U-5706 - CP 4B Meeting-20260916_130234-Meeting Recording

September 16, 2026, 5:02PM

New location between US 74 and US and Roverdale Road. Each end of the project is a three-lane section. And we're on segment one right now. This project will break it up into two segments. Segment one and segment 2 are kind of earmarked on the end. Those are the three lane sections. And then we're coming back with segment 2, which is majority of the new location sections. But section 2 will have the first or the second intersection, which is Y2 County Home Road.

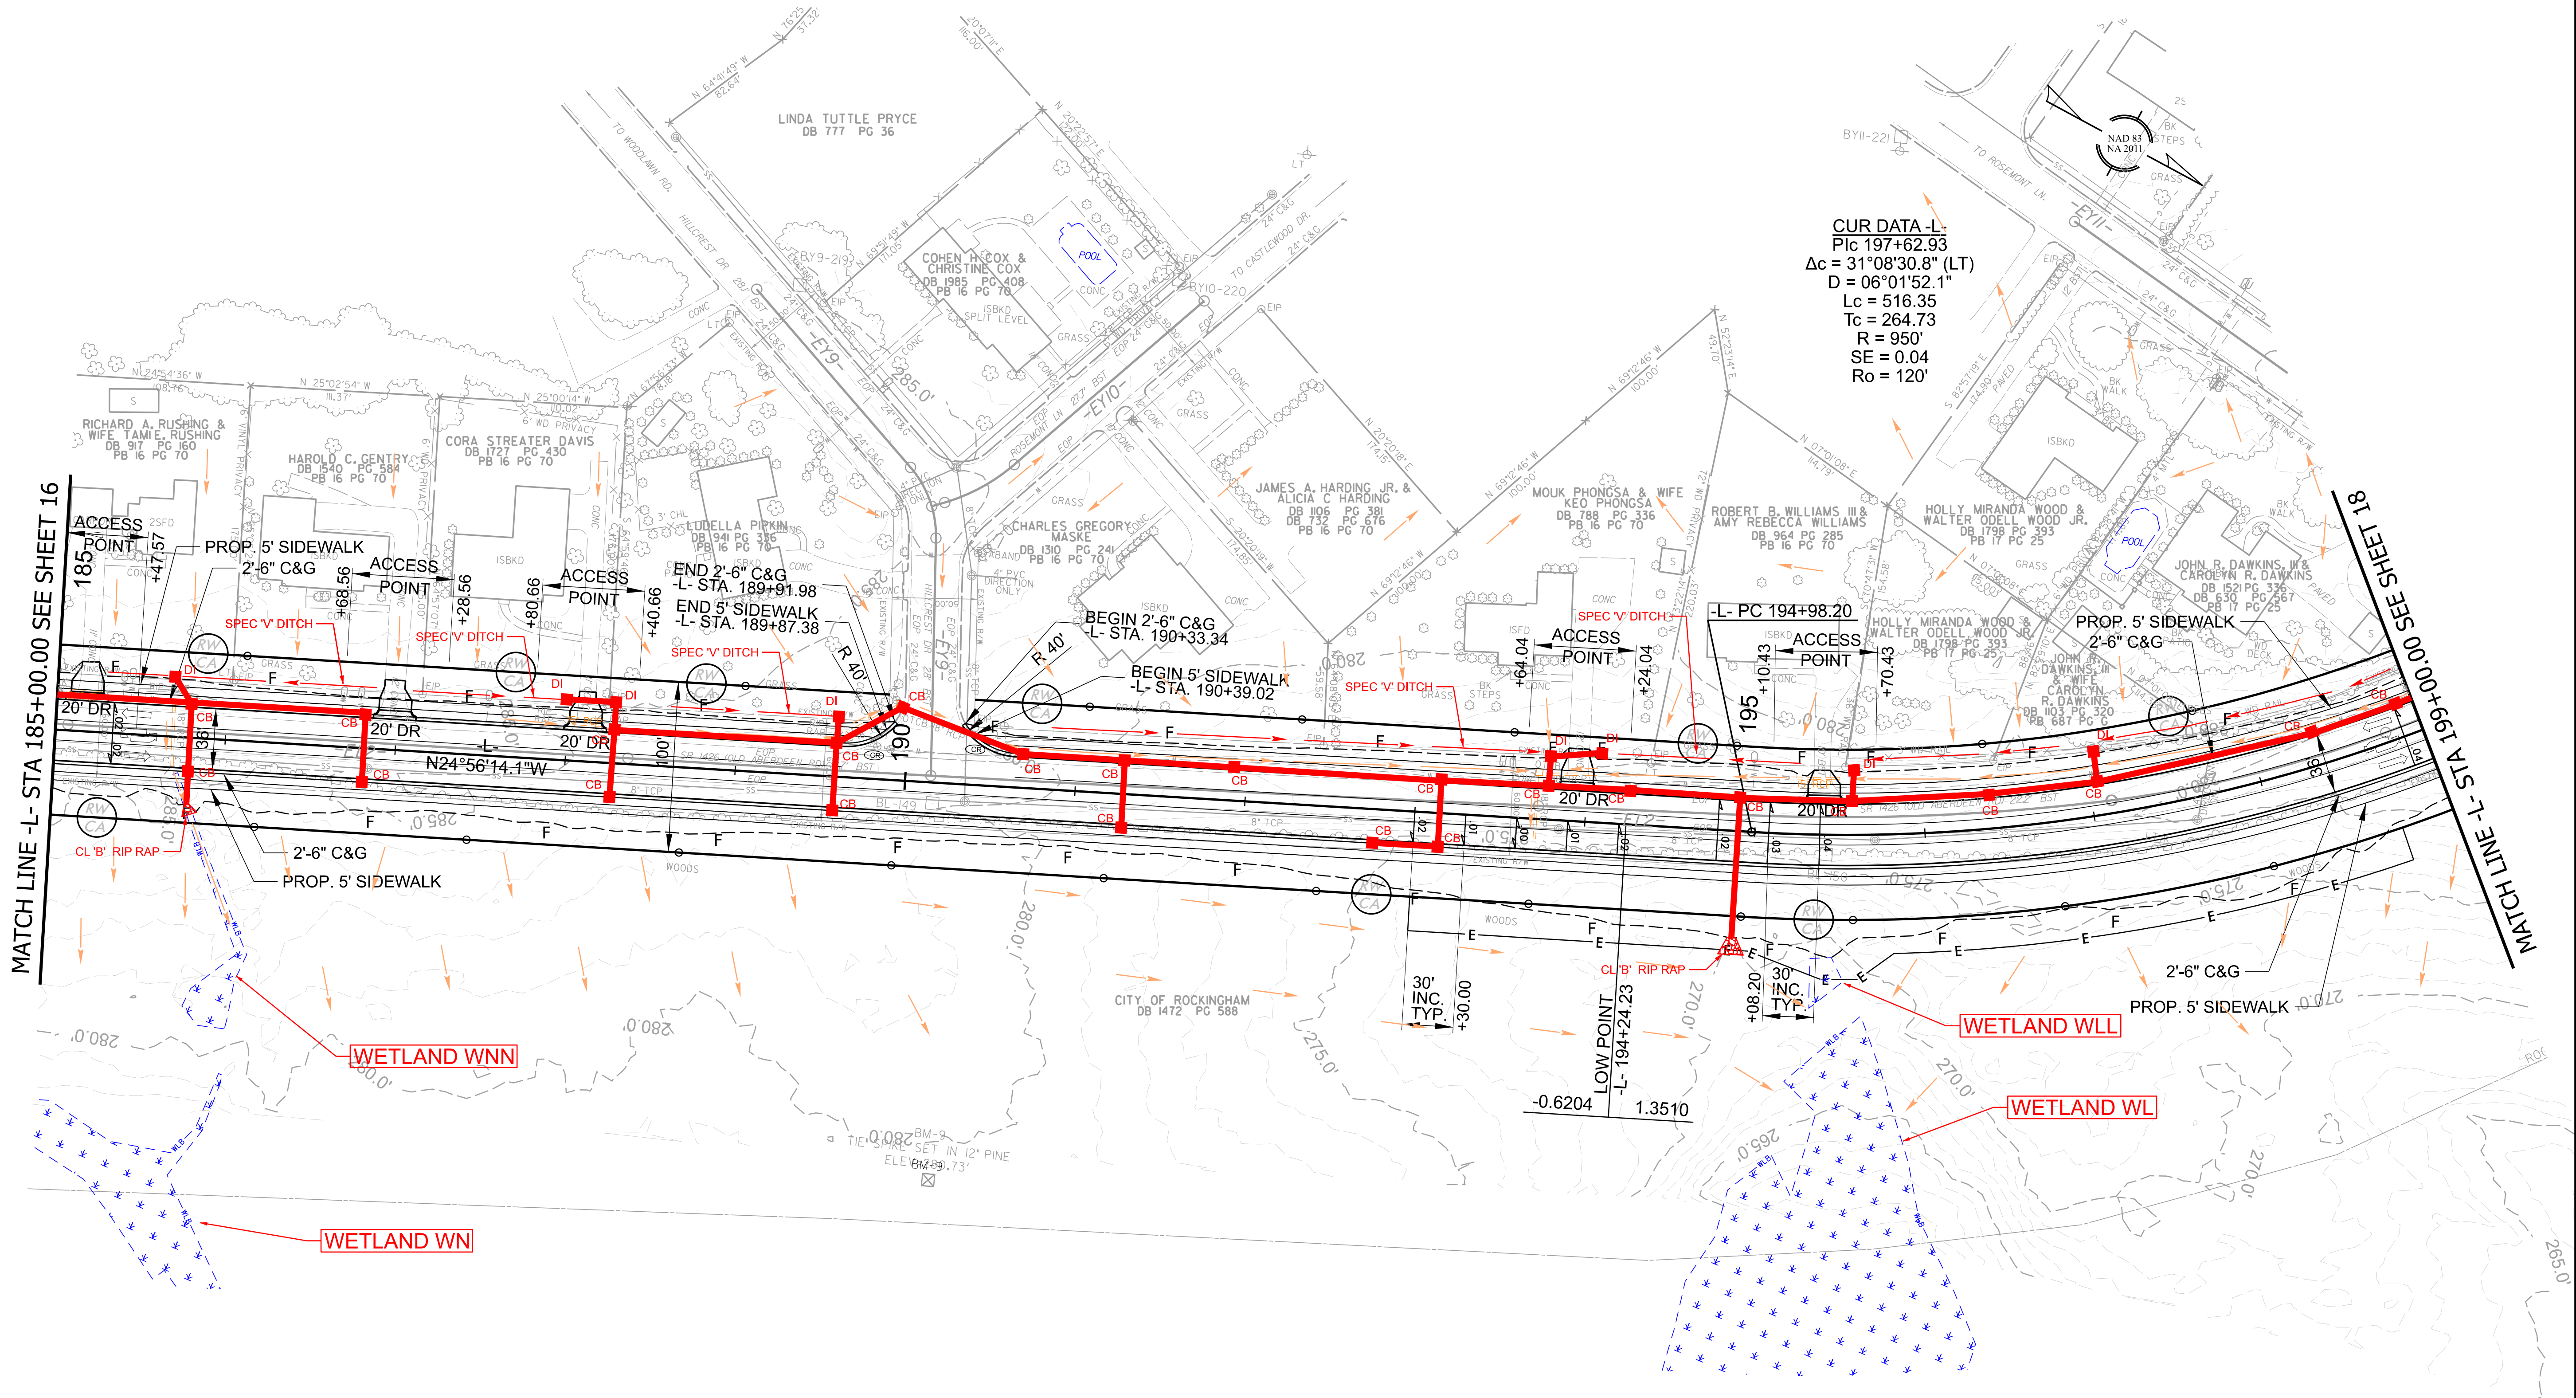
We were wondering about the discharge amount going from the ditch to the stream SYA. Depending on the amount of discharge, do you think we could be tying in the riprap into the ditch itself to prevent channelization or?

Is that not a worry? All right. Explain that exactly. You want the so the new ditch, you would like it to be rip right as soon as it gets to the channel. I think it's that we're eventually talking about the tie and will the velocity as it enters the channel, that little bit of things that we'll see.

I don't know the velocity yet, yeah, but the idea would be to provide some rip ramp to, and maybe even bottom the base a little bit of the channel, just to decrease those velocities. I would imagine being in Rockingham is probably not in this area, but not

This is Steve. I just I was just going to ask us kind of that treatment right at the existing culvert from this drawing, in my old eyes, it looks like just rock. There's no head wall or wing wall or any inlet changes at all for that existing box culvert. Is that correct?

That is correct. We will not be doing any work to the box cover itself, the existing box cover.

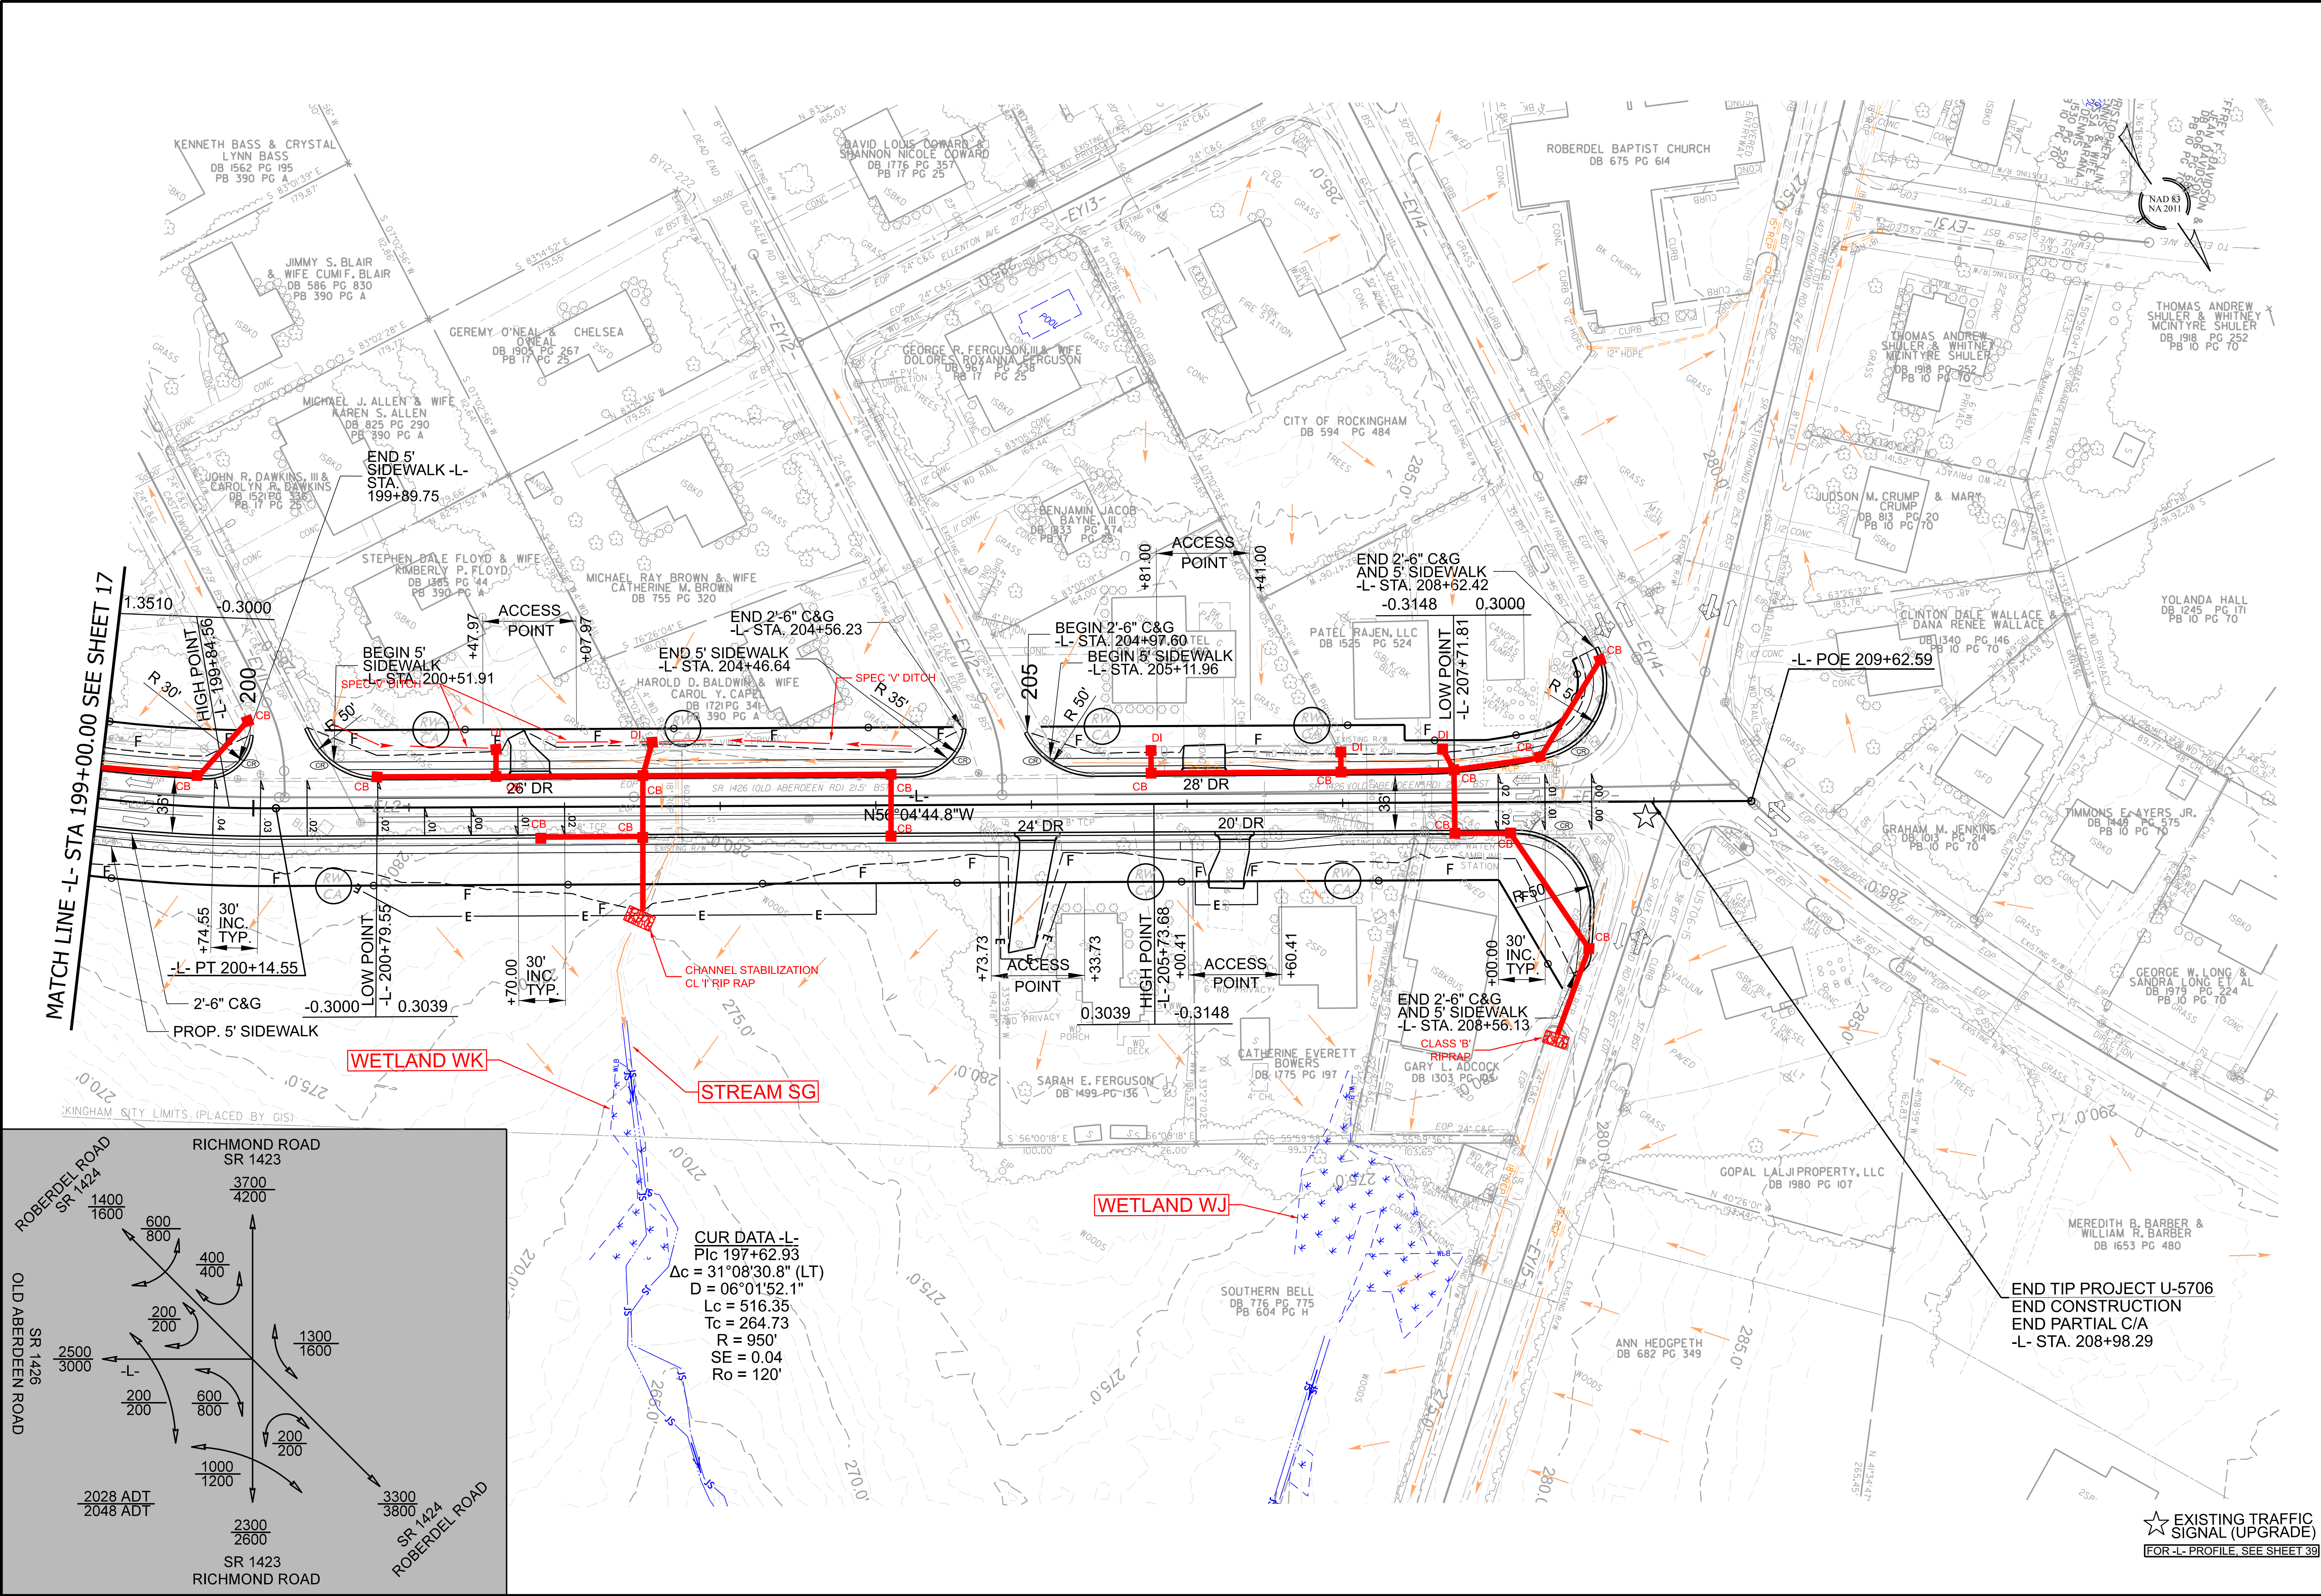
Yeah, this is Steve. The Wetland WR was picked up and maybe Jay can. remind me, I think that when we were doing some of the site visits when we were out there for the preliminary JD, if the areas either had water in them or were met the criteria for wetlands during the time of the inspection, they were included. It was Never in doubt that this the structure. facility, let's use facility, was meant entirely to deal with the water coming from the Zaxby's in the parking lot there. That was understood at that time. And we discussed how that would be handled when and if we got to permitting and We can talk about that now, if, if, if... In general terms, if you'd like, you know, generally... When I'm at this point, I'm... I'm looking at drawings and in this one it looks like your impact within that jurisdictional area is going to be Minimal square feet. And I didn't know if you had any details on that.

And I don't expect that this activity is going to have, and I don't know what the requirements were for putting that in or maintaining that is a storm water control feature as far as capacity and ability to handle and treat whatever's coming off of. Maybe treat isn't the right word to properly handle what's coming off the parking lot from Zaxby's, but I know.

And it looks like it's being handled by an 18-inch pipe now, and that looks like what was going to be.

where the Corps will ask that you identify the area of impact that will be within that jurisdictional area as part of any permit action that you have for this project. And, you know, what we've done in the past is we've much like impacts to other tributaries or wetlands that have been evaluated for, you know, opportunity to provide function. You know, there is a consideration for stormwater basins and all that is taken into consideration.

I don't know how dot or the divisions are handling this, but sometimes divisions usually like just pay the property owner to replace the outlet structure if they need to, or I guess in some cases dot actually builds in the outlet structure in this case.

We will be impacting the existing, so these are has to be replaced, or someone would have replaced.
